Your Ref: OWPC20734
Our Ref: AW/288/18/HH
Please ask for:
Mr R Castro-Parker

Single storey front extension
8 Osborne Way Bognor Regis West Sussex

Thank you for your internet comments made on 28th November 2018 which has been recorded as **'an objection'** with the comments as follows:

PROPOSED GROUND FLOOR PLAN

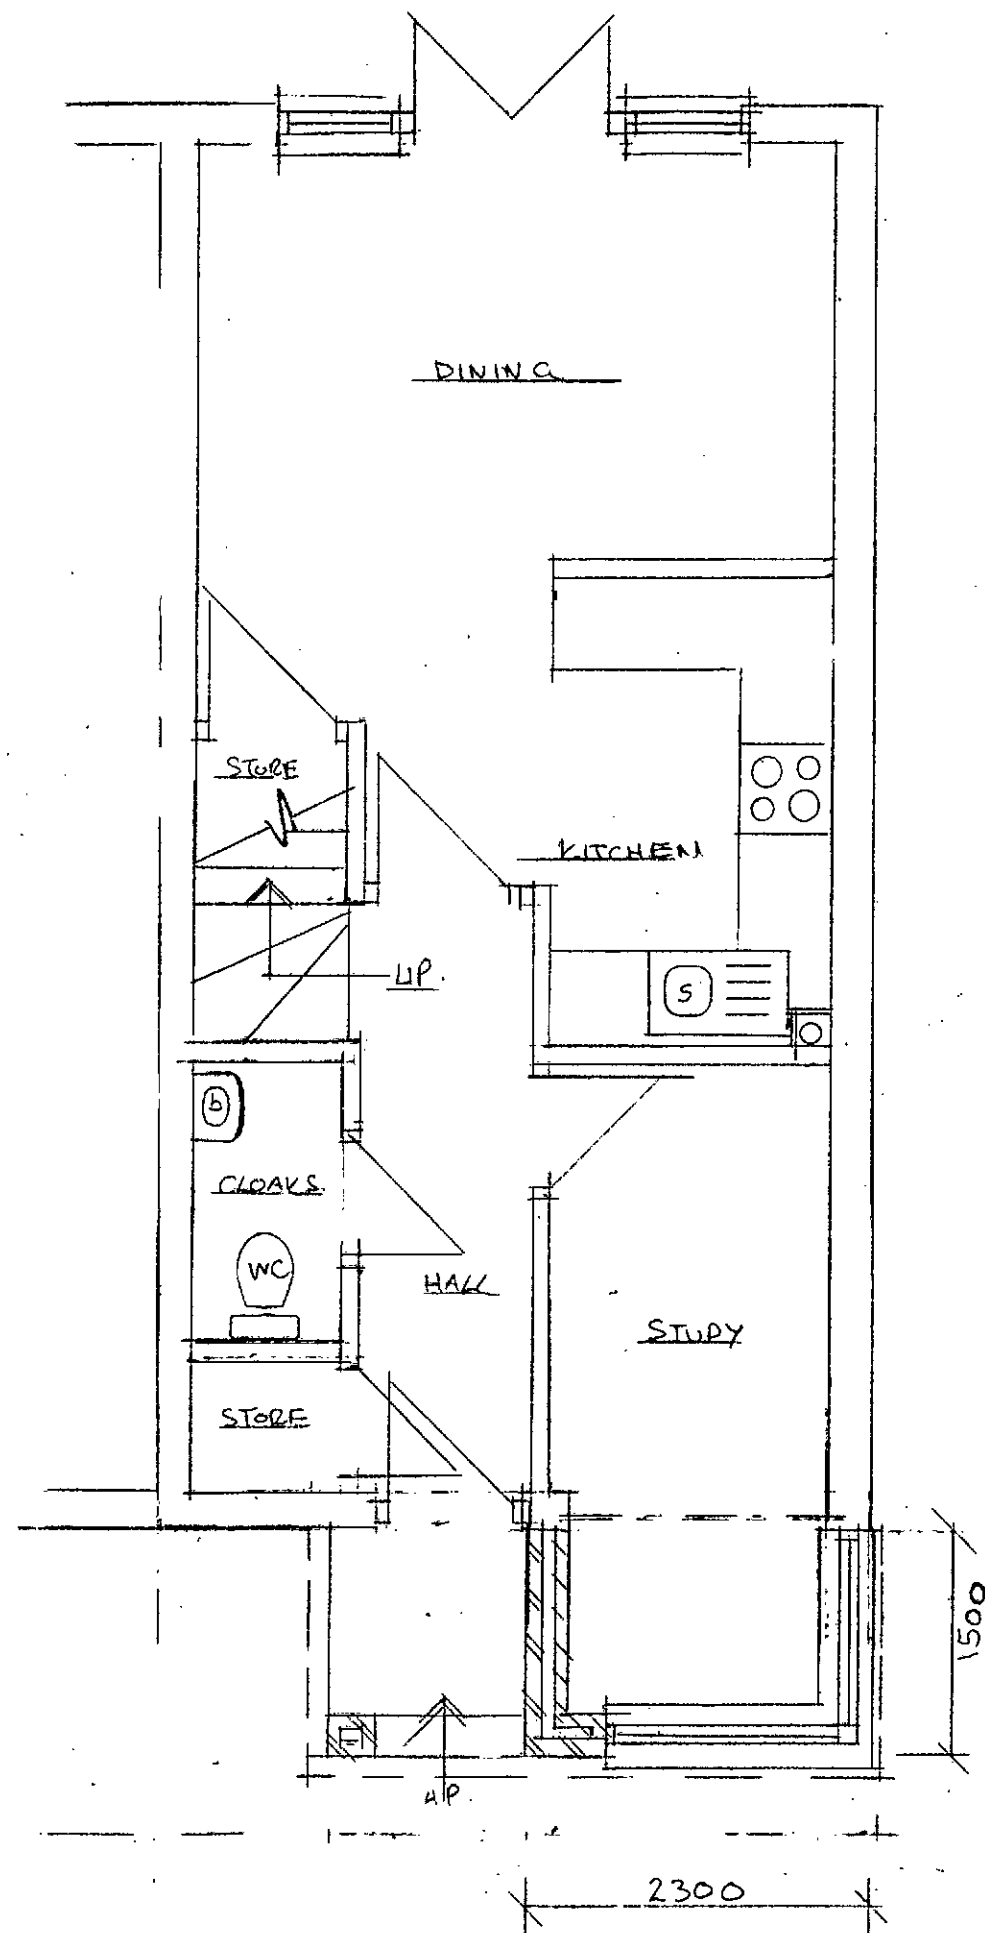
Members strongly opposed the application on the grounds that the proposed extension does not sympathetically relate to and is not visually integrated with the existing building in in siting massing design form scale and materials; because it has an adverse overshadowing overlooking or overbearing effect on neighbouring properties; and because it compromises the established spatial character and pattern of the place. Therefore Members agreed that the application is in direct conflict with Policy D DM4 (a) (c) and (e) of the Arun District Council Local Plan 2011 to 2031 and with the Parish Design Statement Page 7.
